Re: Response to Review Comments
Iron Ridge Subdivision Filing Nos. 1 and 2
El Paso County, Colorado
Entech Job No. 251117
PCD Nos. SF2612 and SF2613

Entech Engineering, Inc. (Entech) has reviewed the CGS comments for the proposed Iron Ridge Filing Nos. 1 and 2. This letter presents our responses to the CGS comments, and the results of groundwater monitoring program. The CGS comments are attached with this response letter. The responses to their comments are presented below:

FINAL PLAT
IRON RIDGE FILING NO. 2
A PORTION OF THE SOUTHEAST QUARTER
SEC. 13, T11S, R66W OF THE 6TH P.M., COUNTY OF EL PASO, STATE OF COLORADO

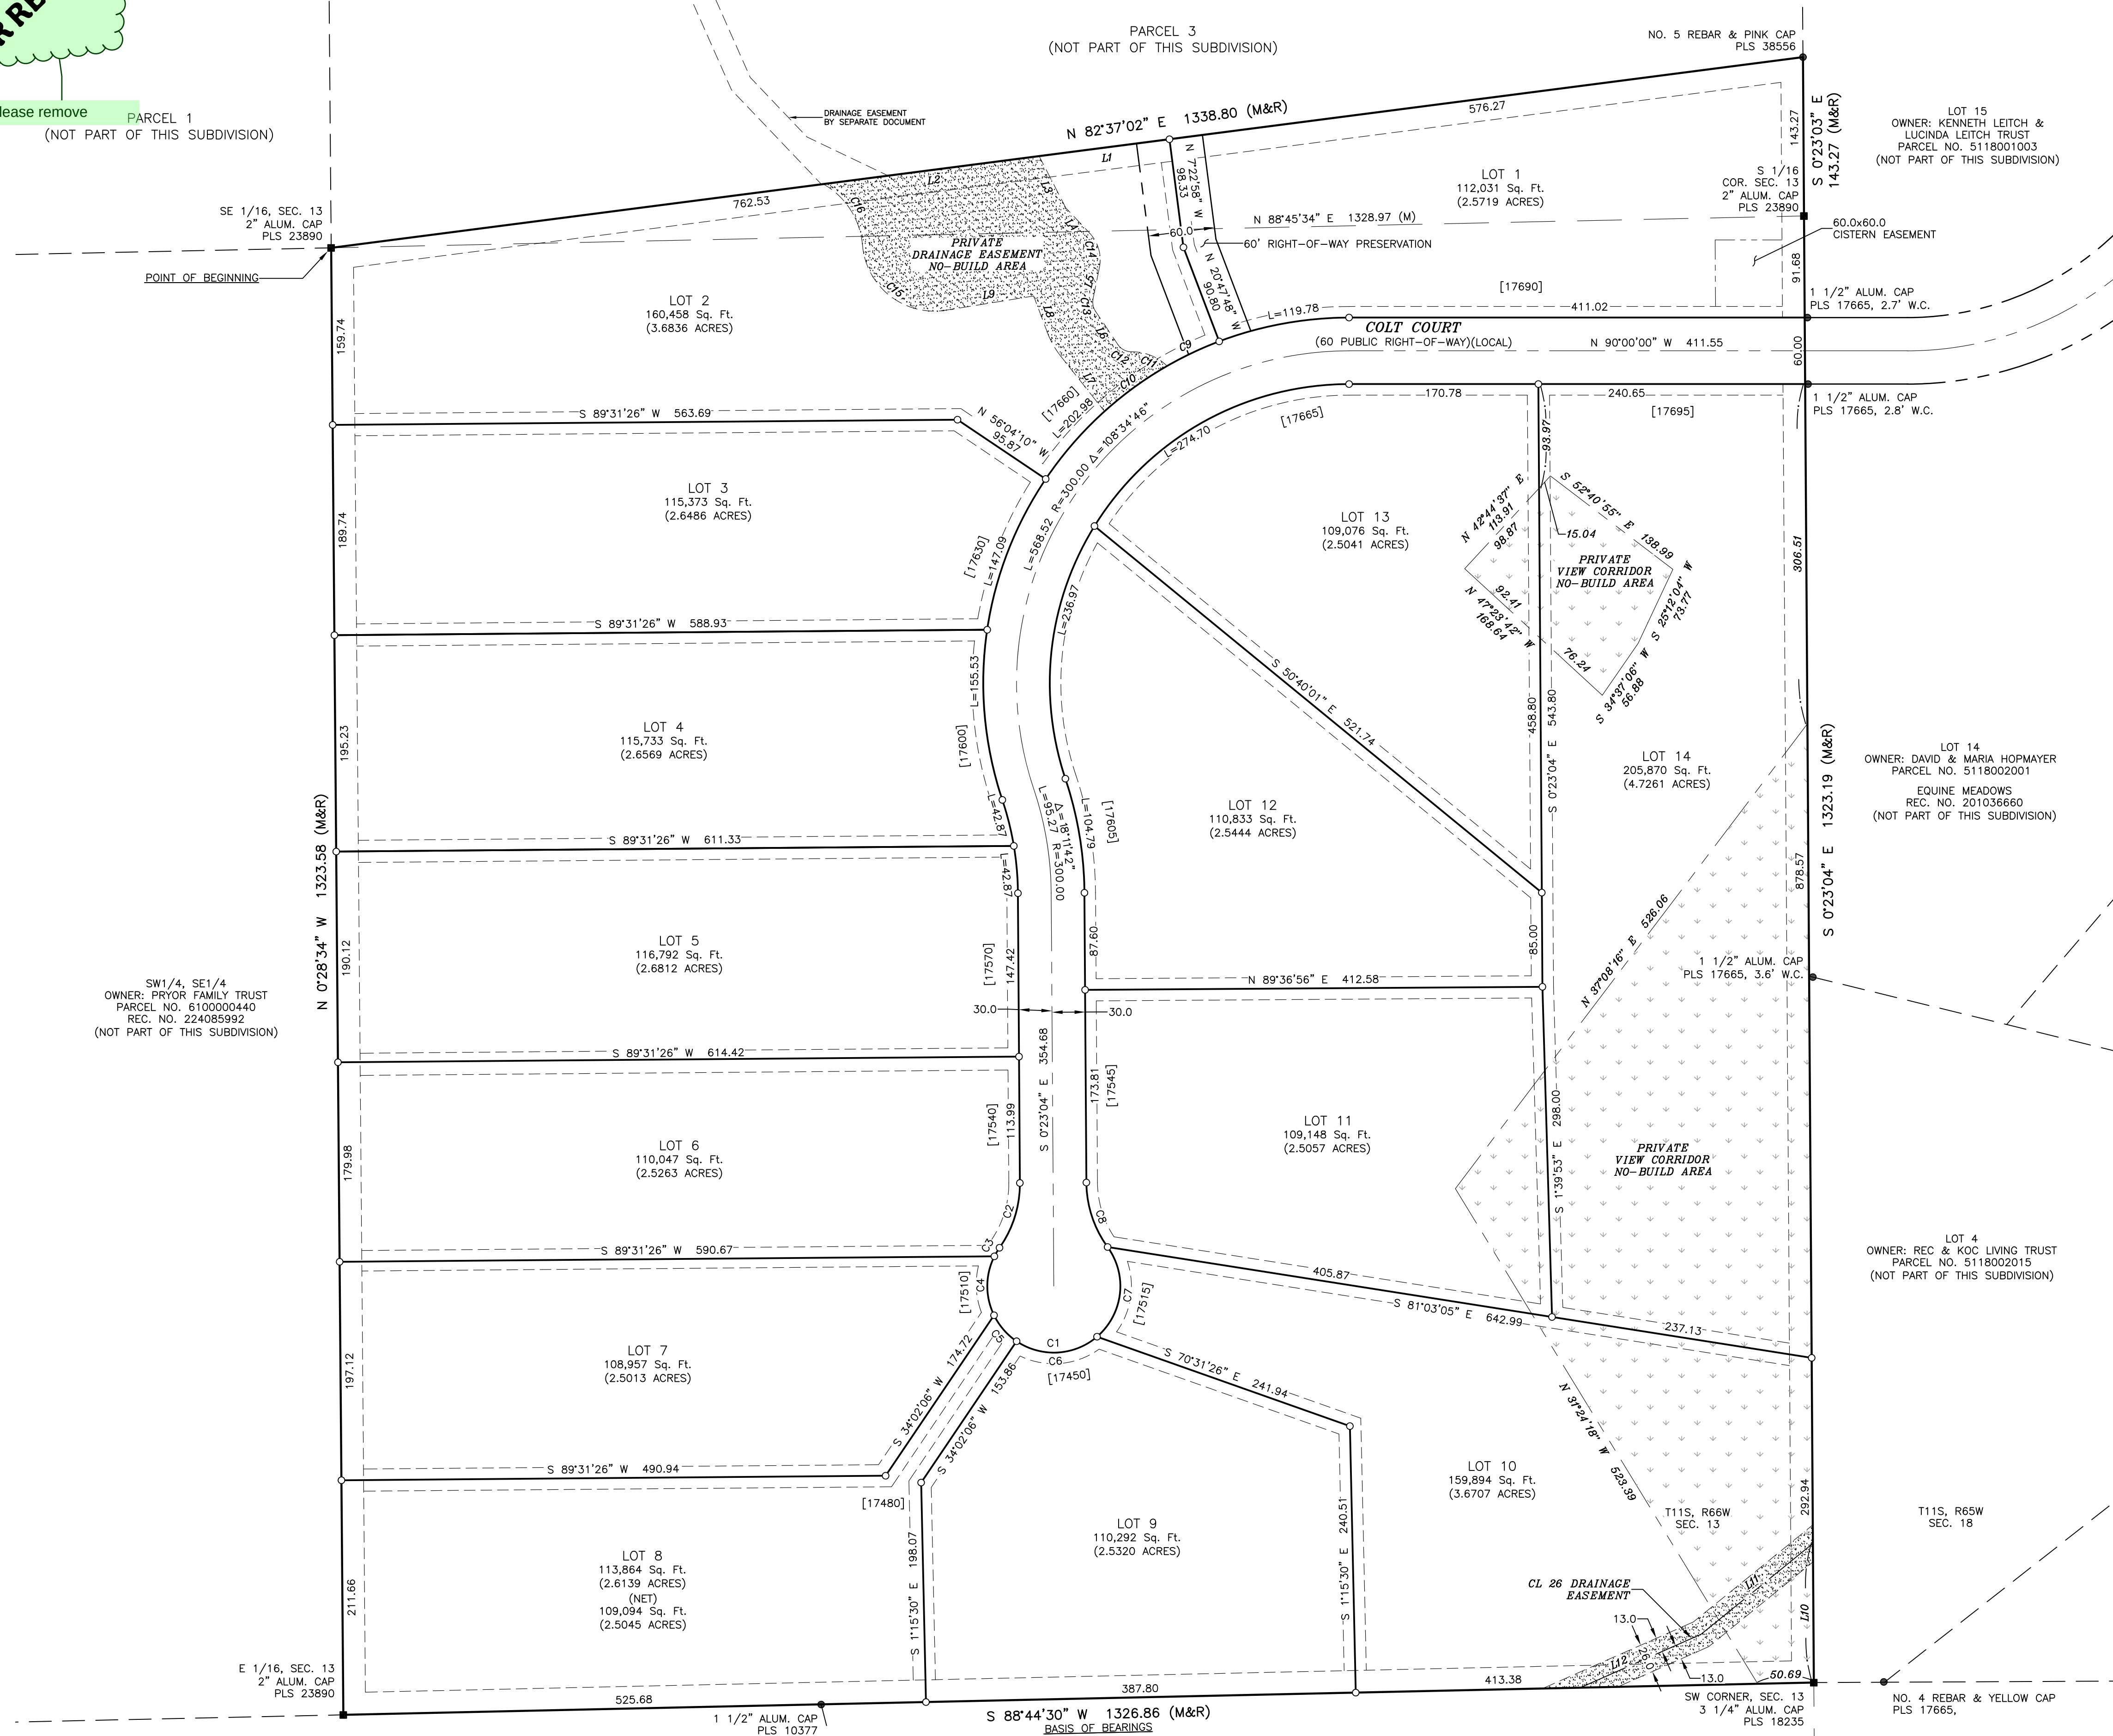
4. Geologic Hazard Statement. A geologic hazard statement, consistent with the El Paso County Land Development Code, should be included on the final plat referencing the geologic report and the identified geologic hazards and constraints applicable to the site.

5. Geologic Hazard Statement. A geologic hazard statement, consistent with the El Paso County Land

Entech Response to Comment 4: The following Geologic Hazard Statement should be included on the final plat.

Areas within this subdivision have been found to be impacted by potential geologic constraints/hazards as detailed in the Soils and Geology Study for Iron Ridge Subdivision prepared by Entech Engineering, Inc. dated September 24, 2025. The geologic constraints/hazards impacting the development include: artificial fill, expansive and locally collapsible soils, downslope creep, potentially unstable slopes, erosion, ponded water, shallow bedrock, seasonal shallow groundwater, and elevated radon potential. The report is available in the El Paso County Planning and Community Development records (www.epcdevplanreview.com) under County File Nos. SF2612 (Filing No. 2) and SF2613 (Filing No. 1).
